Director, Transport Assessments Planning Services
Department of Planning, Industry and Environment
GPO Box 39
Sydney, NSW 2001

Application: SSI 7485

I write regarding the proposed modification to M4-M5 Link, Mod 2 The Crescent overpass and changes to pedestrian infrastructure in North Annandale, Rozelle and Rozelle Bay Foreshore area.

Figure 4-5 The Crescent/Johnston Street/Chapman Road intersection

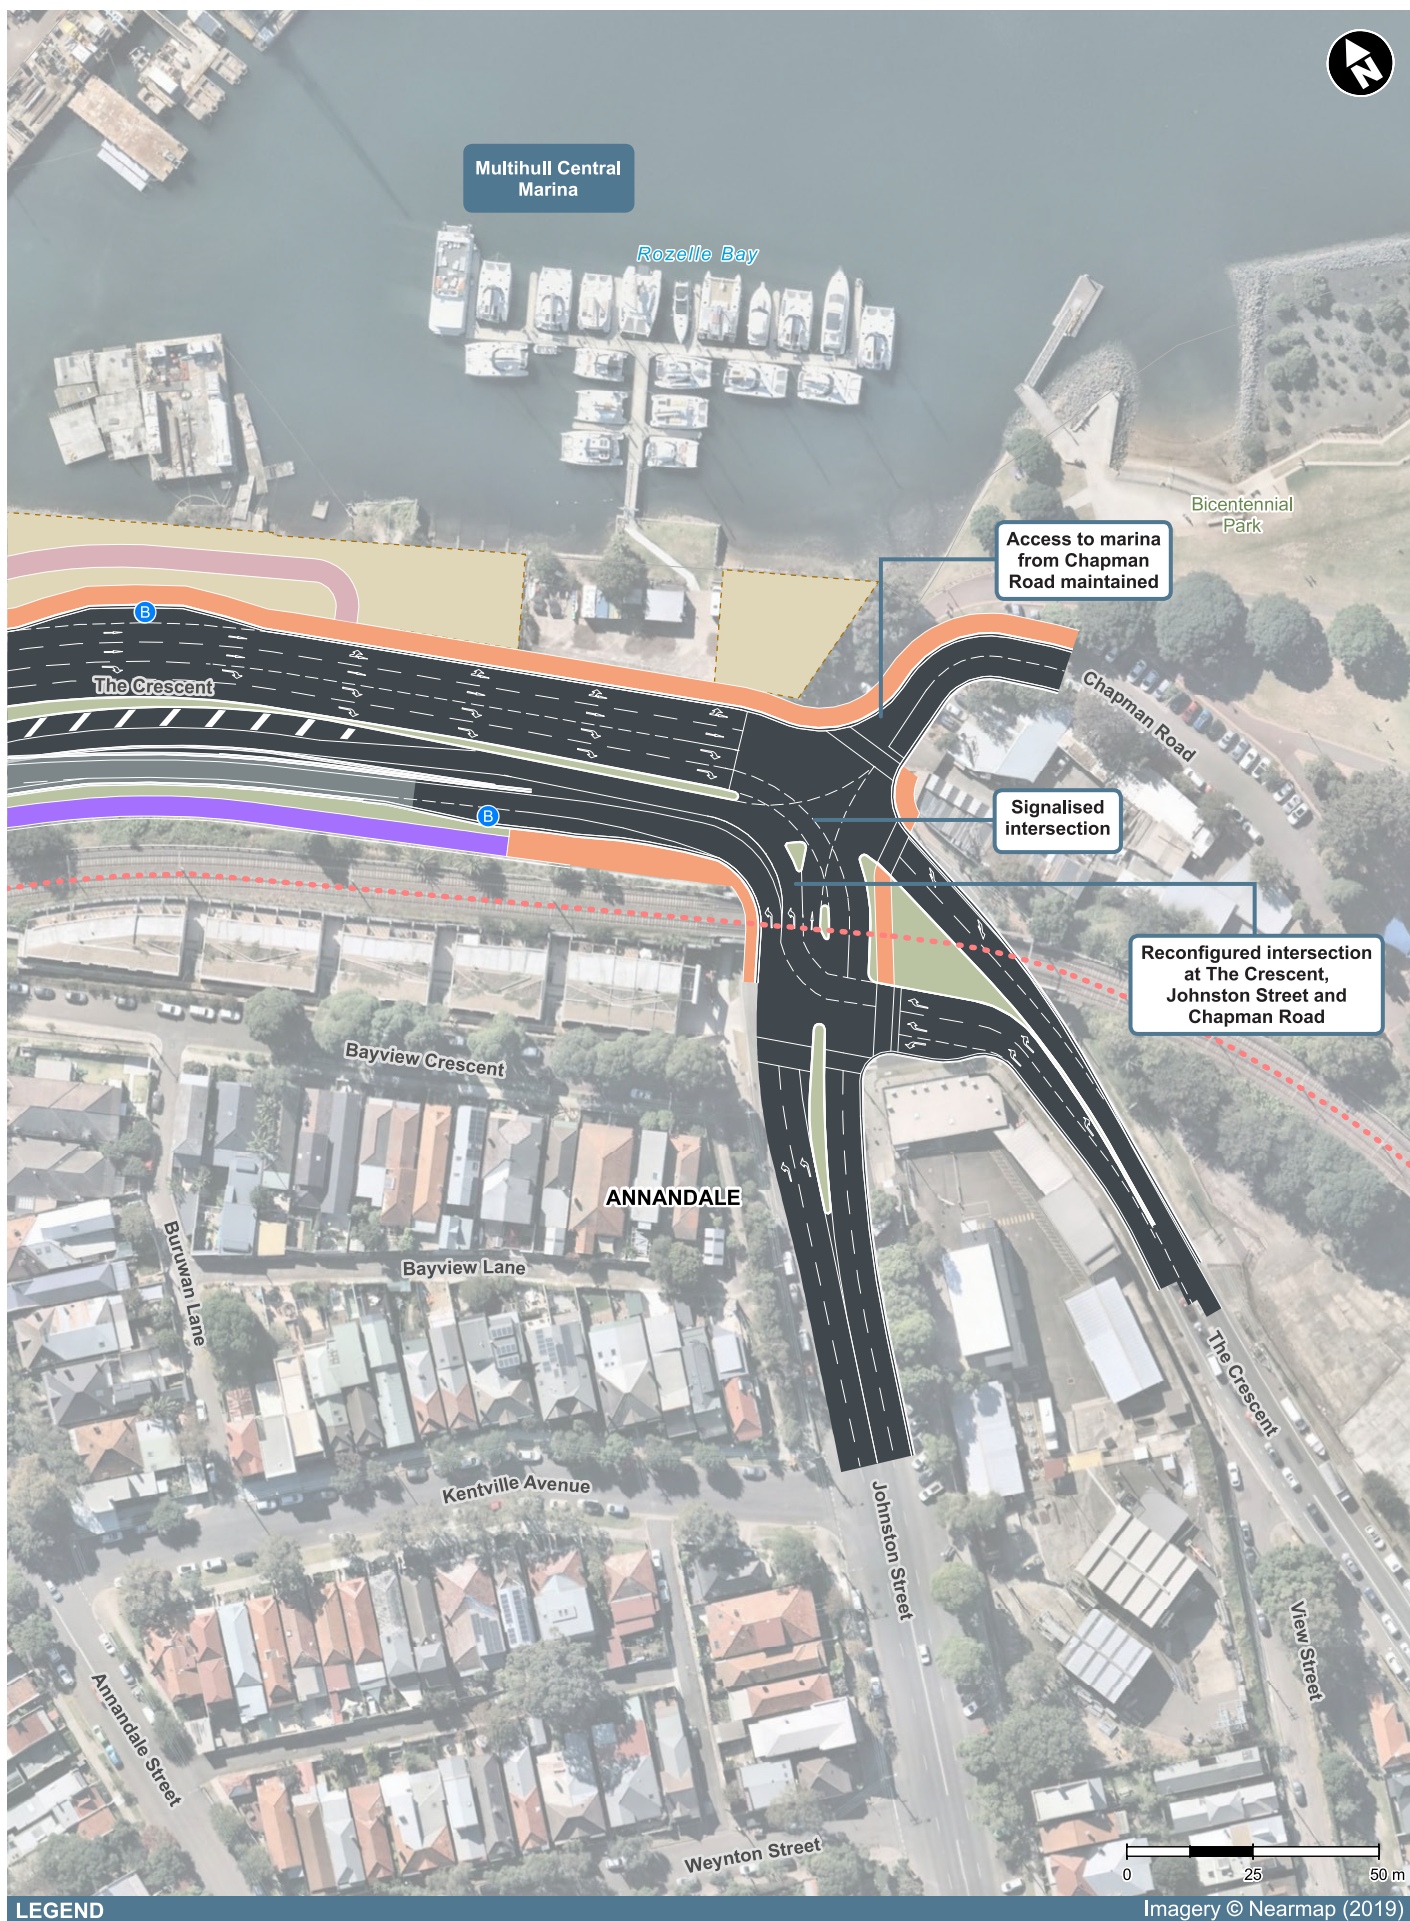
- The significantly reduced safety and increased risk for pedestrians and cyclists with removed access over The Crescent to Bicentennial Park and the increased traffic along Johnson Street.
- Being required to cross five sets of pedestrian lights at The Crescent as my option to reach the foreshore from Annandale or from Rozelle Bay light rail stop.
- Removal of direct active links to the foreshore, cutting the community off from the area and the proposed revitalisation of the entire Bays Precinct, including linking the Light Rail and Bus stops to a Ferry wharf and Metro station.
- Urban and landscape design that is being built before a finalised Masterplan for the area.
- Traffic changes that limit movements around the suburb and create further congestion in the local streets of Annandale, Forest Lodge, Glebe, Lilyfield and Rozelle with no planning to deal with these.

• I live North Annandale. I currently cycle from Edna St Lilyfield via Railway Pde to the Crescent near Rozelle Bay Light Rail / Burrawong Park now claimed by WestConnex. I currently have one set of light crossing to Jubilee Park - in this modification I have no direct Access. & many crossings over Johnson St & Chapman St.

Figure 4-6 Elevation: Indicative view of Rozelle Rail Yards Pedestrian and Cycling Green Link

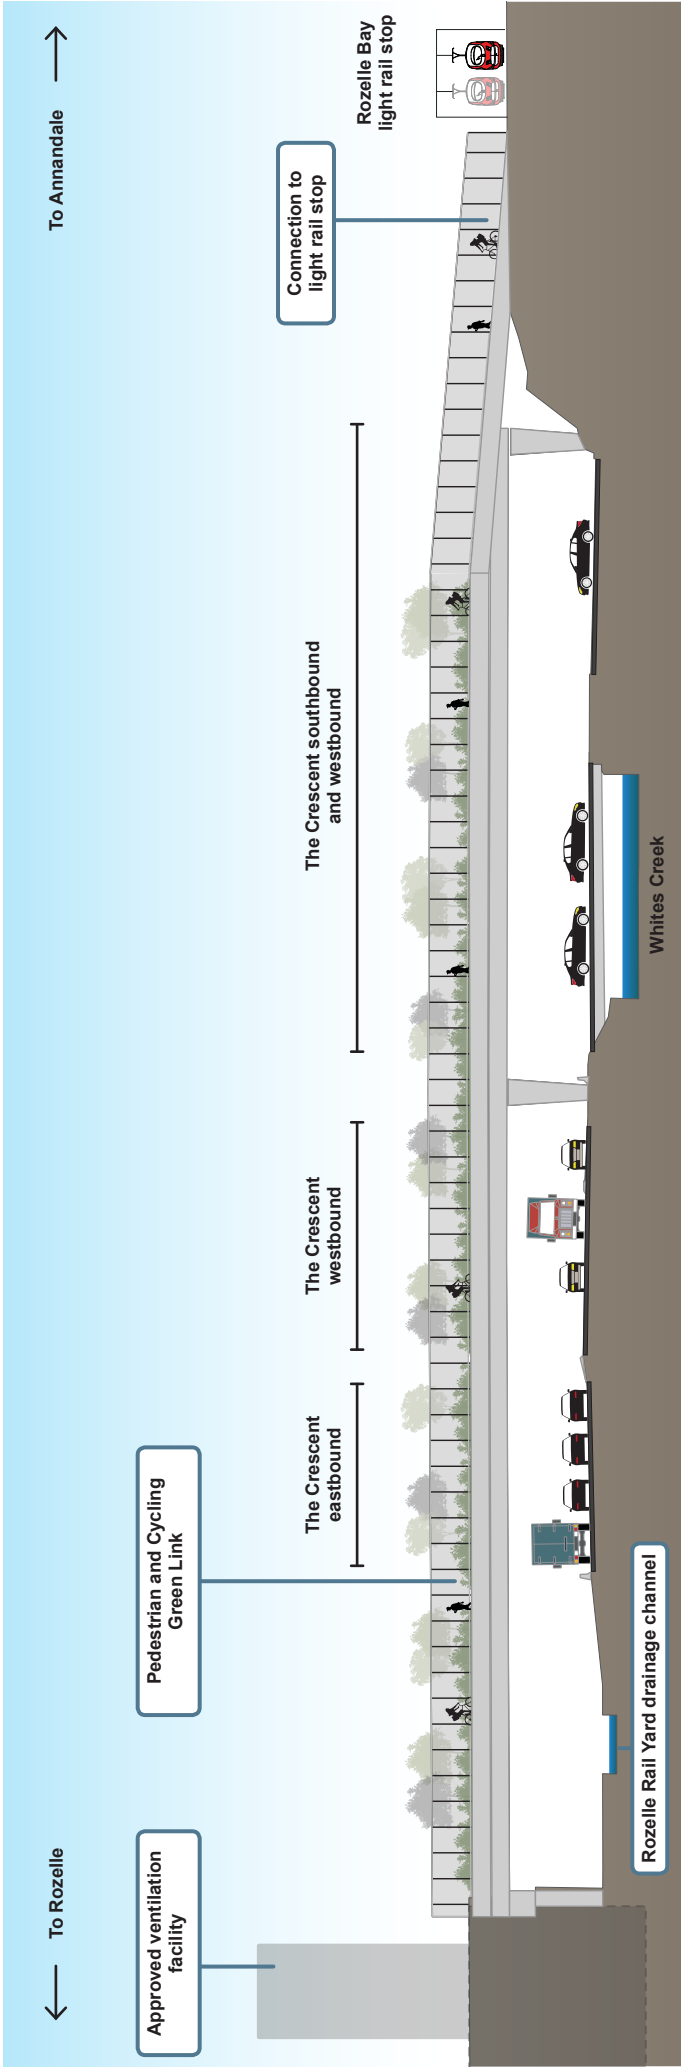
I request RMS work with the community to explore alternate design options to the proposed new car overpass design and the changed pedestrian and cyclist links. I am seeking the reinstatement of the safe, direct access from the approved EIS GreenLink to create a continuous green open space connection from the Rozelle Rail yards and Annandale to the foreshore. The GreenLink was more than just a walk way - it put people central to the design, maximising safety, and providing much needed accessible open space for the community now and into the future Bays Precinct design.

- Reinstate the GreenLink connecting communities and green open space from Rozelle to Bicentennial Park
- Relocate and design pedestrian and cyclist connections that are continuous, safe and direct.
- Design the modification infrastructure and active links in response to the character of the suburbs, the location of the foreshore and it's potential future development.
- Provide pedestrian and cyclist paths that maximise people safety and do not force them onto busier streets, unsafe concrete plazas and caged walkways.
- Integrate active and direct connections to all active transport – including the future Metro West and Foreshore Ferry Wharf
